# **East Anglia ONE North and East Anglia TWO Offshore Windfarms**

## **Applicants' Comments on East Suffolk Council's Deadline 4 Submissions**

Applicant: East Anglia TWO and East Anglia ONE North Limited  
Document Reference: ExA.AS-13.D5.V1  
SPR Reference: EA1N\_EA2-DWF-ENV-REP-IBR-001227

Date: 3<sup>rd</sup> February 2021  
Revision: Version 1  
Author: Royal HaskoningDHV

Figure: 8g
CHVP3: PROW between Moor Farm and Little Moor Farm

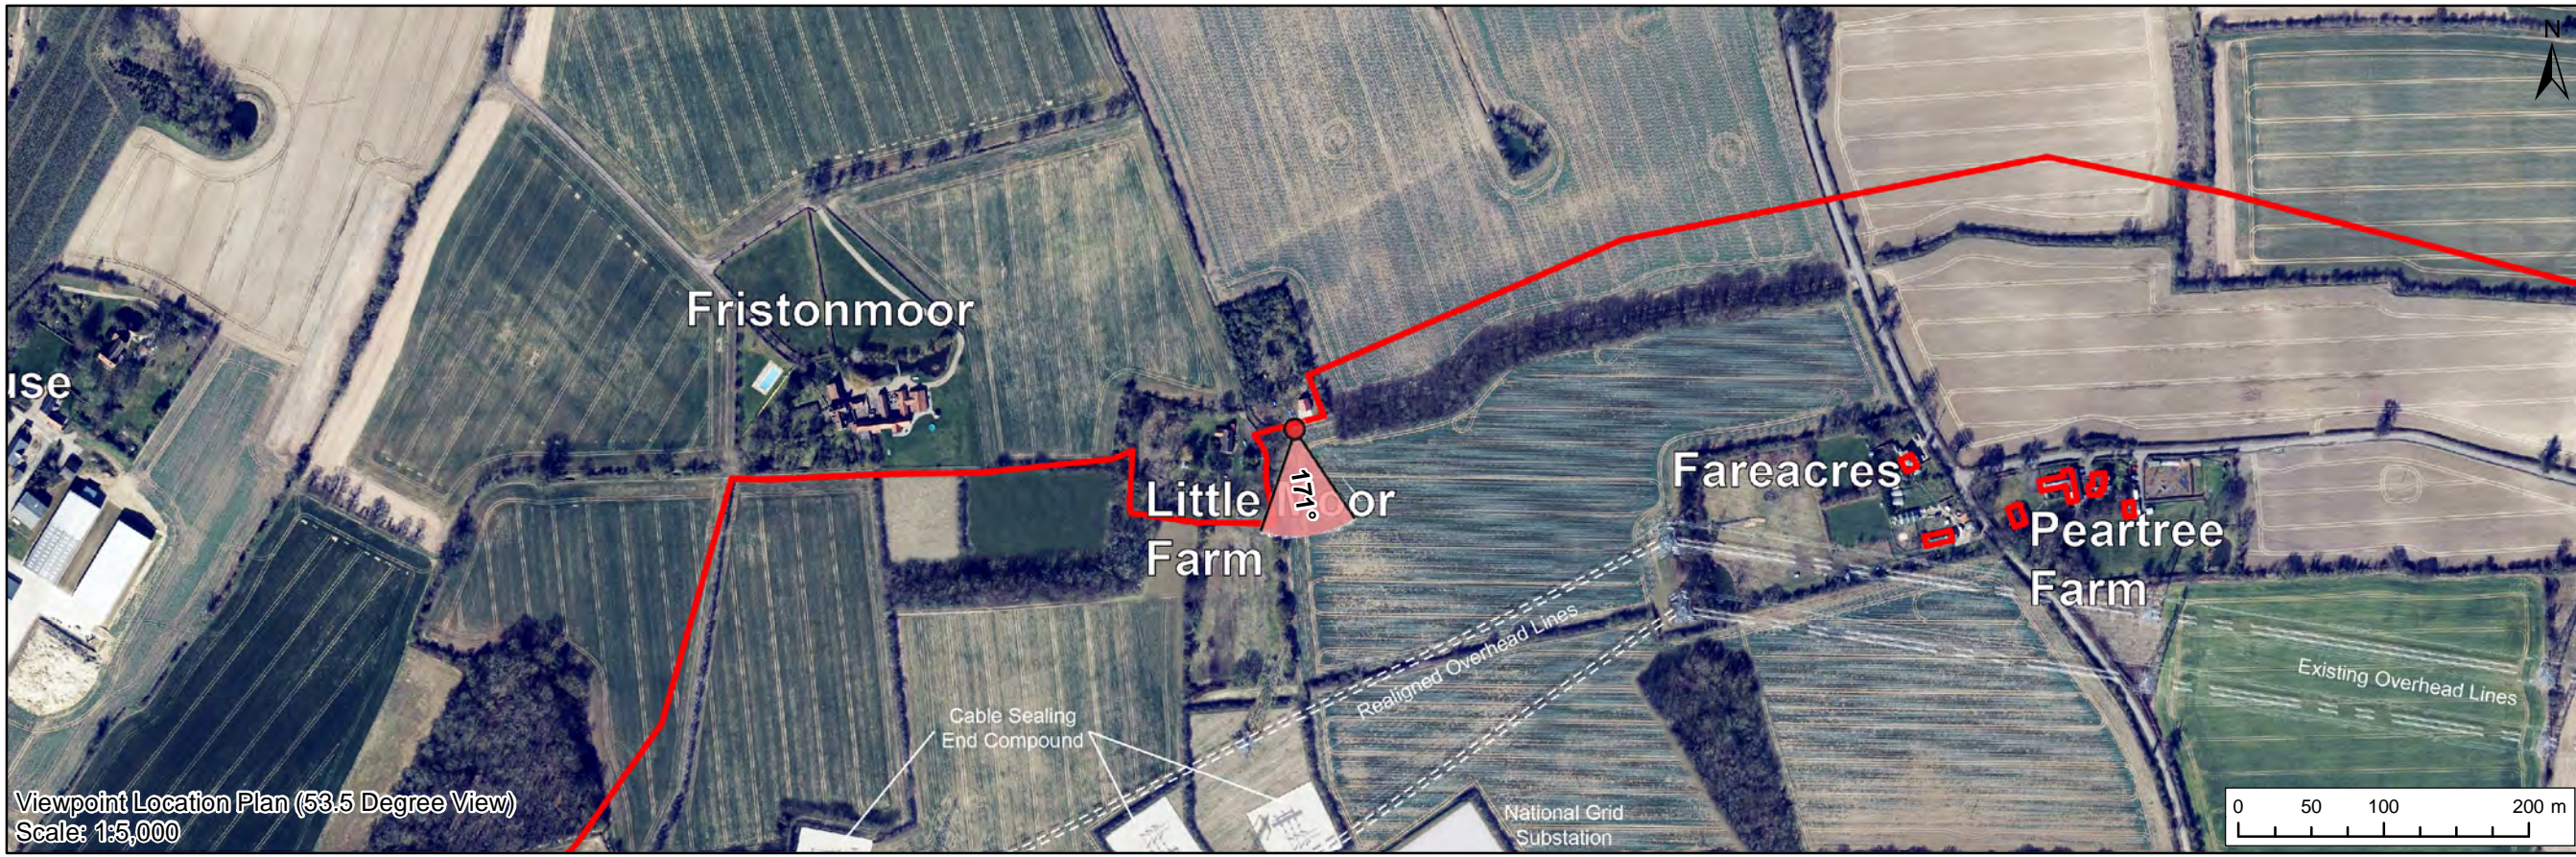
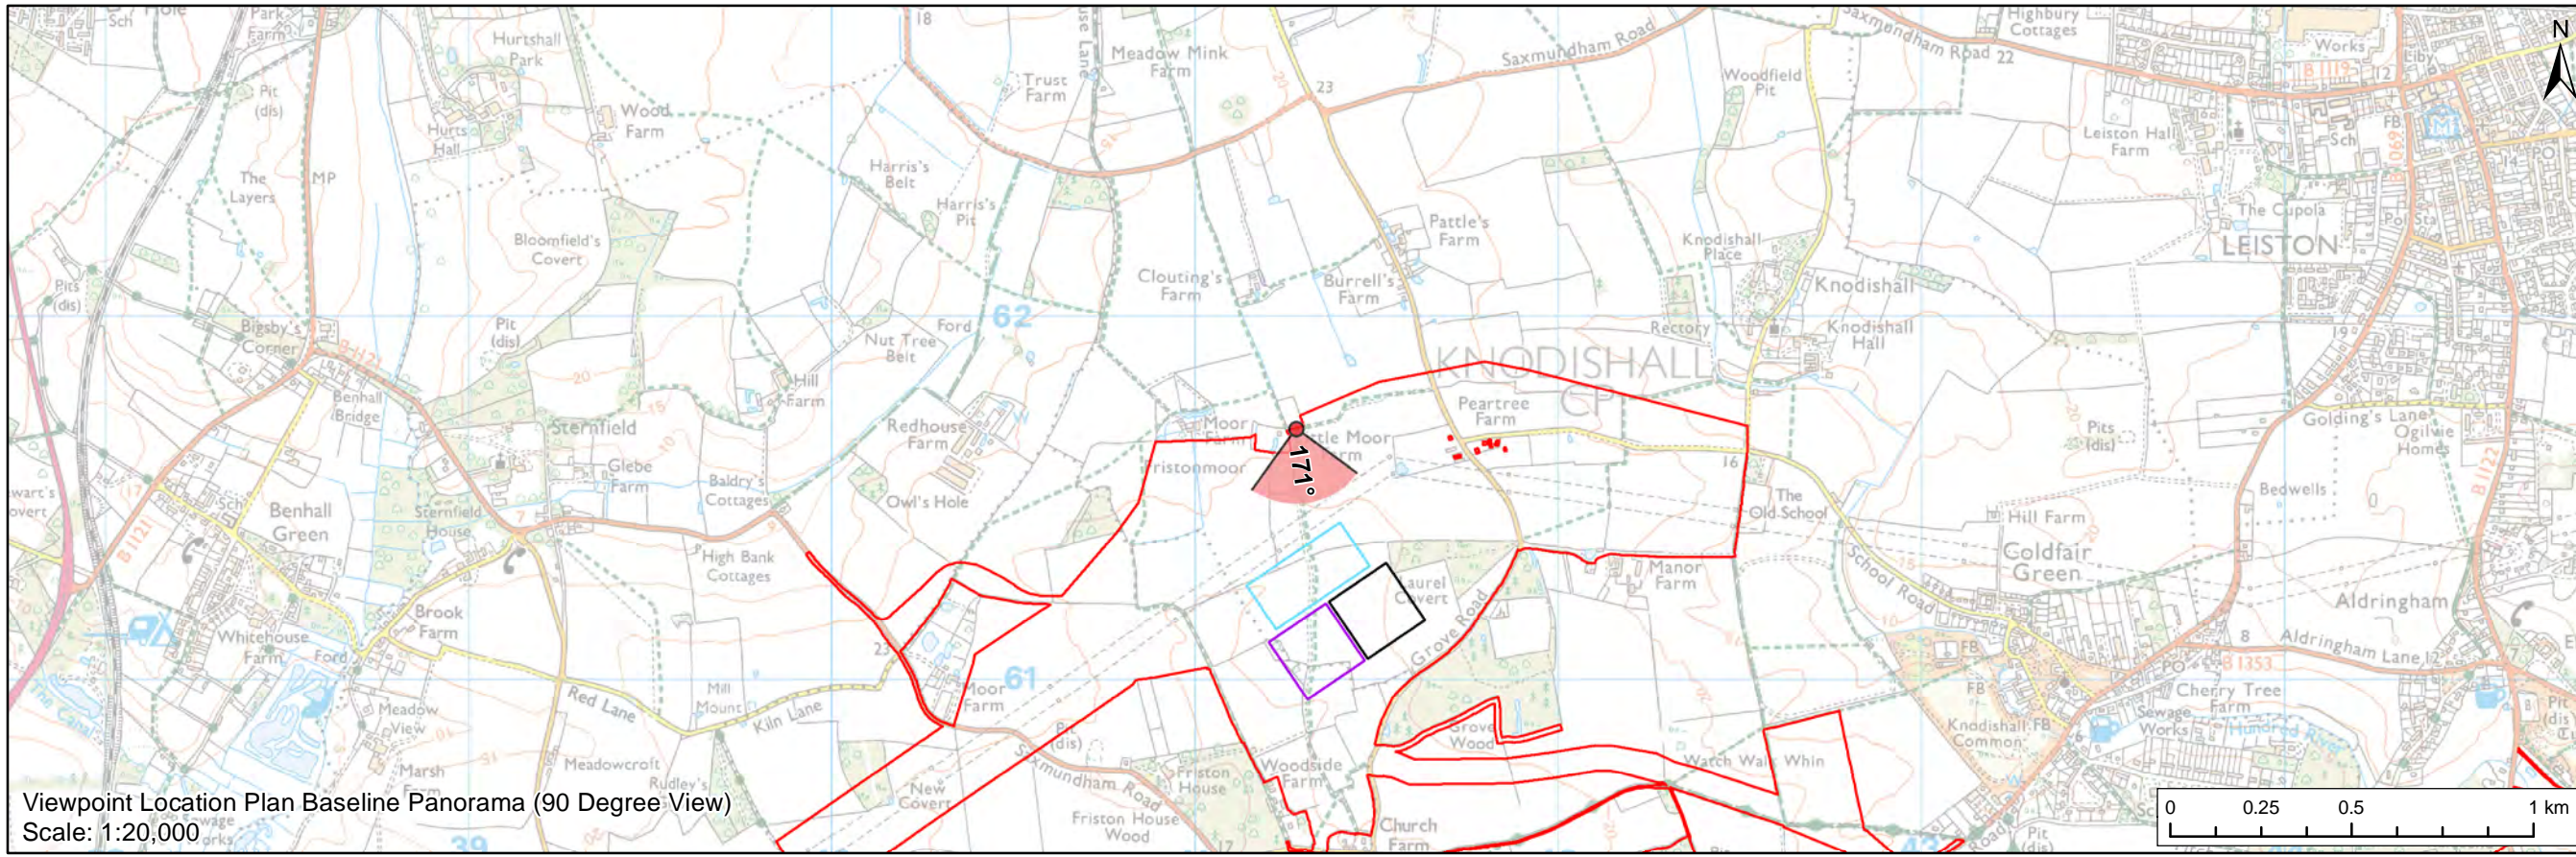
2	<p><b>ESC's comments from a heritage perspective.</b></p> <p>In CHVP3, the reduction in height of the substations does not appear notable. The reduction in the scale of the substations is most noticeable from CHVP4, due to the low height of the proposed vegetation. In this viewpoint the overall height of the infrastructure is lower, and the eastern substation is a less continuous mass, broken up at the centre. Notwithstanding this, the combined visual impact of the substations and the National Grid substation is still substantial.</p> <p>The reduction in the scale of the substations is also noticeable in CHVP5, however this updated visualisation highlights the concern the Council had with this viewpoint previously, in that it is taken from behind the building. In the original viewpoint, the largest elements of the western substation were clearly visible to the left of the weatherboarded outbuilding above the treeline after 15 years. In the updated visualisation, the reduction of the substations means that the western substation is just covered by the weatherboarded outbuilding, and the proposed vegetation covers the</p>	<p>The Applicants have provided updated photomontages and an updated assessment in its <b><i>Landscape and Visual Impact Assessment Addendum</i></b> (REP4-031) and <b><i>Heritage Assessment Addendum</i></b> (REP4-006) submitted at Deadline 4.</p> <p>The Applicants note that, in CHVP5, the western onshore substation remains visible until such time that the mitigation planting has established to sufficient height to provide screening of the infrastructure (as seen in the 15<sup>th</sup> year of operational phase photomontage (Figure 10h) (REP4-010)). The Applicants accept that moving the viewing location would lead to different, perhaps less interrupted, views of the onshore substations. However, by their nature photomontages are a tool to inform the assessment of potential landscapes and visual impacts and potential impacts upon heritage setting and represent a static visualisation which takes account of existing structures which provide screening.</p>

ID	Written Representation	Applicants' Comments
	<p>National Grid Substation. From this viewpoint it therefore seems that the revisions have made a significant visual change, however this could be misleading, as it is unclear how visible the substations would still be from further along the footpath or from within Woodside Farm's curtilage to the north. Based on the other updated visualisations, it is likely that the top of the substations would still be visible above the treeline at 15 years, and that the scale of the substations would still be notable. Additionally, as noted previously, the proposed vegetation would still be a barrier in itself, which detracts from the open agricultural setting of the listed buildings.</p> <p>Both the reduction in scale of the infrastructure and the changes this allows to the locations of the substations are notable in Viewpoint 1. This viewpoint is most relevant in landscape terms, as it does not form part of a significant heritage viewpoint. As a part of the setting of Woodside Farm, however, it appears that the proposed landscape mitigation would have a similar visual impact as before the revisions.</p> <p>Viewpoint 2 is relevant as a view toward the development from north of the church and Viewpoint 9 is a wider view which shows the church in the background. In the updated visualisation of Viewpoint 2 there is a visible reduction in the scale of the infrastructure for the western substation. Viewpoint 9 still shows the tops of the substation infrastructure above the treetops in the backdrop of the church, although lower than in the previous visualisation. Notwithstanding this, the proposed developments would still be of a notably large scale and it would interrupt important views and the relationship between the church and the historic properties to the north and would diminish the open rural character of its wider setting.</p> <p>The reduction in scale has made a difference in the visual impact of the development, in particular from medium-range viewpoints. However, the scale of the development is still so great that these revisions would not be</p>	<p>The <b><i>Landscape and Visual Impact Assessment Addendum</i></b> (REP4-031) and photomontages in its Appendix 1 demonstrate that the Projects' design refinements, including the reduction in the footprint of each of the onshore substations and their resulting relocation, lowering of the finished ground levels and reduction in the maximum heights of the buildings and external equipment, as well updates to the <b><i>OLMP</i></b> (REP4-015), are beneficial in reducing the landscape and visual effects of the Projects' onshore substations. Landscape and visual effects are considered from a number of viewpoints including Viewpoints 1, 2 and 9.</p> <p>The reduction in visual effects resulting from the Projects' design refinements are most notable in these viewpoints from the village of Friston to the south, where a combination of the above design refinements results in a reduction in magnitude and resulting significance of effects in some views. The changes in visual effects are smaller from the north and north-west as the National Grid infrastructure is more prominent, and there is less scope for planting in constrained areas underneath or in close proximity to the existing overhead transmission lines.</p> <p>However, even from these locations the overall scale and massing of the onshore substations and intensity of effects has been reduced. The Applicants refer to its <b><i>Landscape and Visual Impact Assessment Addendum</i></b> (REP4-031) and photomontages in its Appendix 1 submitted at Deadline 4 for further commentary and updated assessments of the Projects' onshore substations and National Grid infrastructure, in light of the design updates to the substations and <b><i>OLMP</i></b> (REP4-015).</p>
